**Consultation Response from KC,
Lead Local Flood Authority**

2023/92317 Newsholme Food Group, New Hey Road, Oakes, Huddersfield, HD3 4BZ

Erection of extensions to form production and warehouse areas

Date Responded: 4th July 2024

CLIENT			
WOOLTEX UK LTD			
PROJECT			
PROPOSED EXTENSIONS NEW HEY ROAD HUDDERSFIELD			
DRAWING TITLE			
PROPOSED SITE PLAN			
Rev.	Notes	Date	Drawn
*	*	*	*
SCALE		1:500 AT A1	07.23 AD
PROJECT No.		DRAWING No.	Rev.
1869		07	-

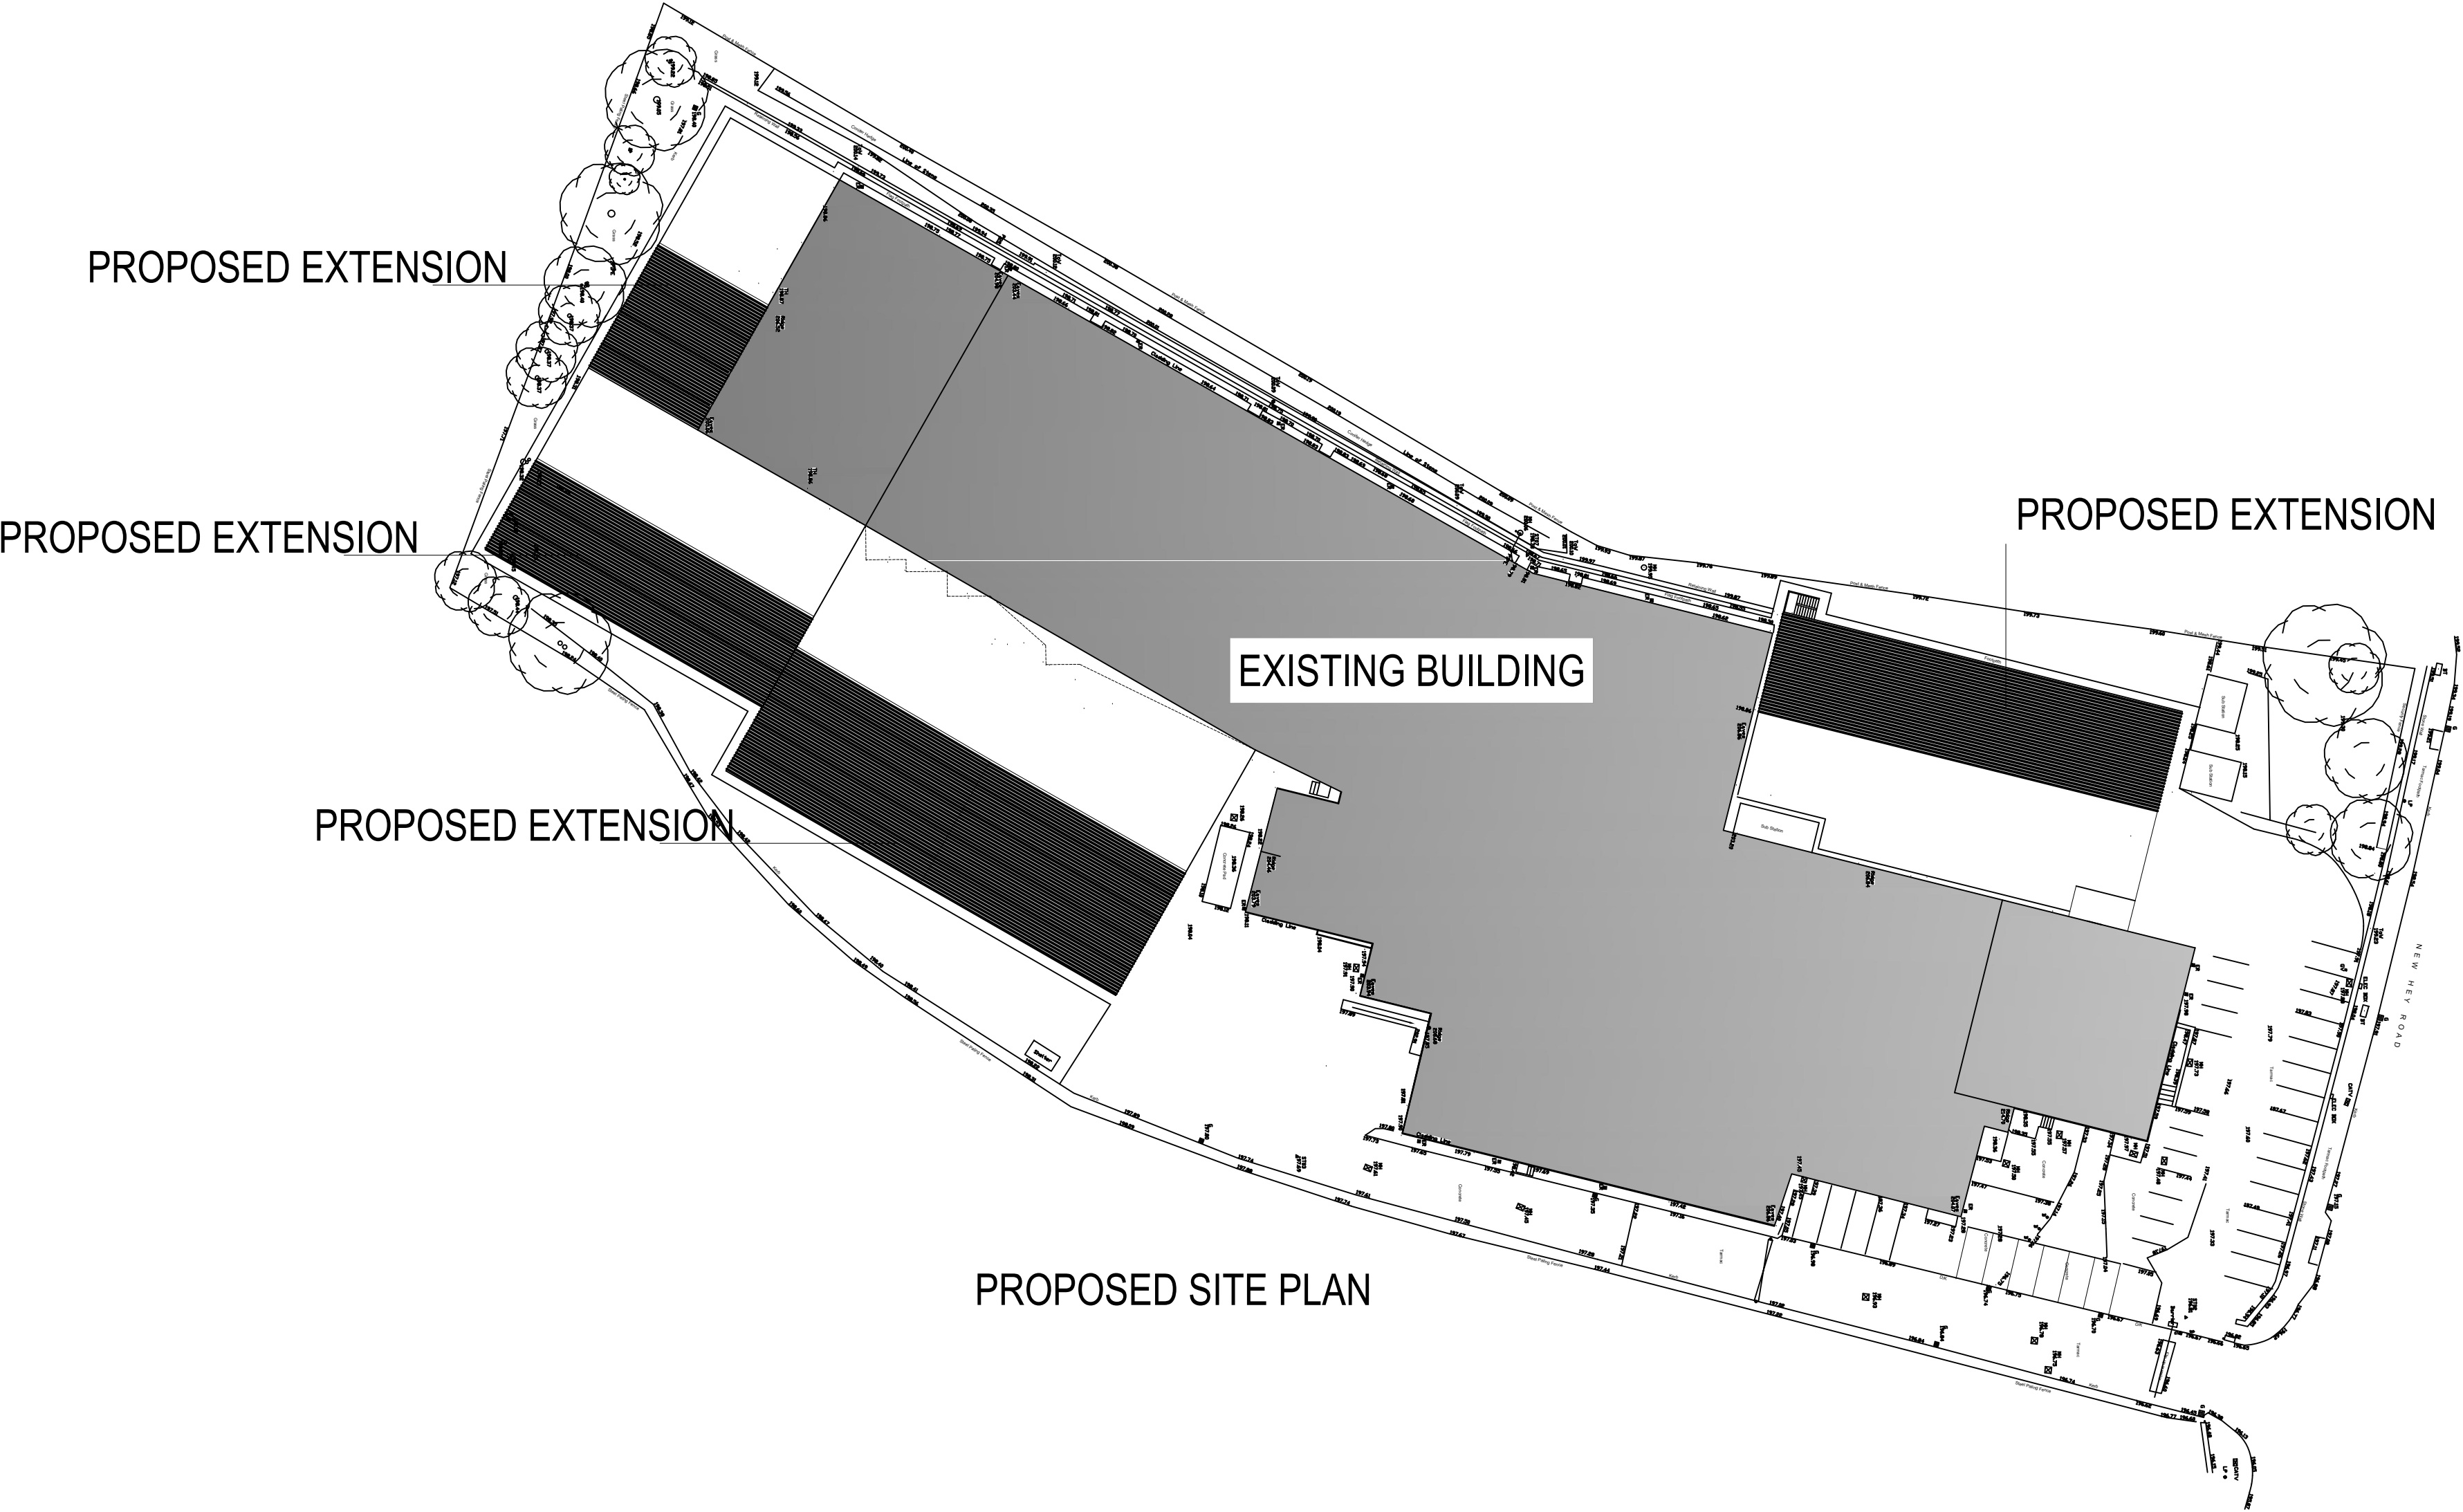
However, it is not clear how the new drainage is isolated from existing drainage prior to attenuation. We do not recommend building over existing drainage. Where this cannot be achieved, surface water drainage from existing buildings may need to be amalgamated with the new and increase discharge rates and recalculations of attenuation requirements will be needed. To be approved, the LLFA needs satisfaction that space can be made for drainage requirements.

A plan to renew existing drainage that is not fit for purpose needs to be outlined if this application can be granted conditional approval.

It may be prudent to have a short meeting where this can be discussed prior to resubmitting. The size of outgoing pipework in relation to existing and new connections must also be analysed for flood risk.
